# CITY OF ALBUQUERQUE

November 16, 2021

**Re: Dions NM 22**  
**9620 Universe Blvd NW**  
**Traffic Circulation Layout**  
Architect's Stamp 08-03-2021 (B10-D003H)

TRAFFIC CIRCULATION LAYOUT
APPROVED
11/19/21
Date
Signed

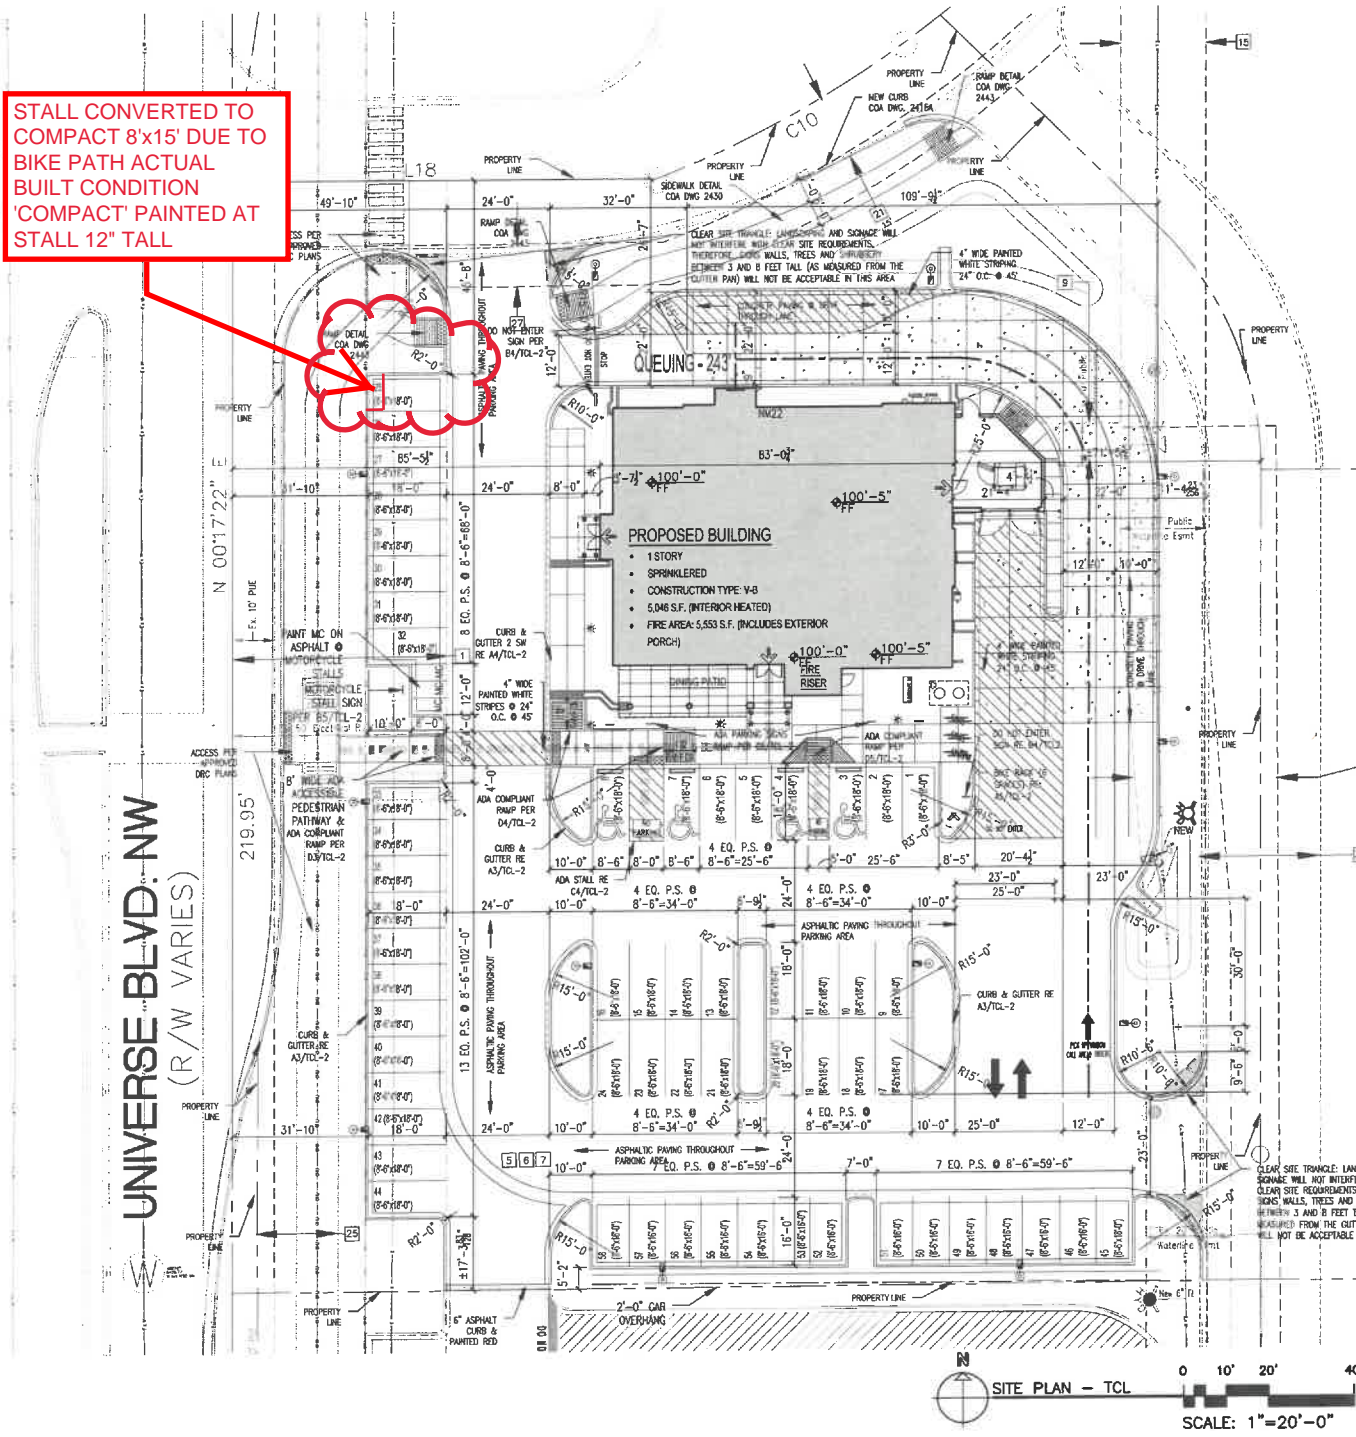
- Proposed sidewalk on northern portion of site will need to be labeled as SIDEWALK DETAIL not RAMP DETAIL. Please adjust text.
- A Condition of Final C.O. Approval for Dions:
  1. Work Order CPN 670982 be built/constructed and approved by COA.
  2. Dutch Bros Coffee built, approved and Final CO approved

2. **Motorcycle parking spaces:** Please reference sign face detail B5/TCL-2 instead of proposed text 2/TCL.
3. Proposed ADA parking stall aisle ramp (C5/TCL-2) is not acceptable. Please provide an alternate design and remove proposed shown on sheets TCL-1 & TCL-2.

4. ADA parking stall signs need to be referenced ( detail: C5/TCL-2) on sheet TCL-1
5. Per DPM, a **6 ft. wide ADA accessible pedestrian pathway** is required from the ADA parking stall access aisles to the building entrances. Please clearly show this pathway and provide details. **Prior comment not addressed (according to detail C4 & D5 of sheet TCL-2 details).**

6. Provide a copy of refuse approval. **Comment not addressed**
7. All one-way drives shall have **"One Way" and "Do Not Enter" SIGNAGE** and pavement markings. Please show detail and location of posted signs and striping. **Comment not addressed. Need to provide Do Not Enter signs (both sides of exit lane) at end of drive thru lane. Another concerns below that were not addressed:**

- Pavment marking details need to be provided (**prior comment**).
  - 'Do Not Enter' sign face detail will need to be provided (**prior comment**).

8. The minimum drive through lane width is 12 feet with a 25 foot minimum radius (inside edge) for all turns. (A 15 foot radius can be used with an increase in lane width to 14 feet). **Need to address this comment at end of drive thru lane geometry.**
9. Please provide a letter of response for all comments given.
10. A copy of receipt for Re-sbmittal payment will need to be provided.
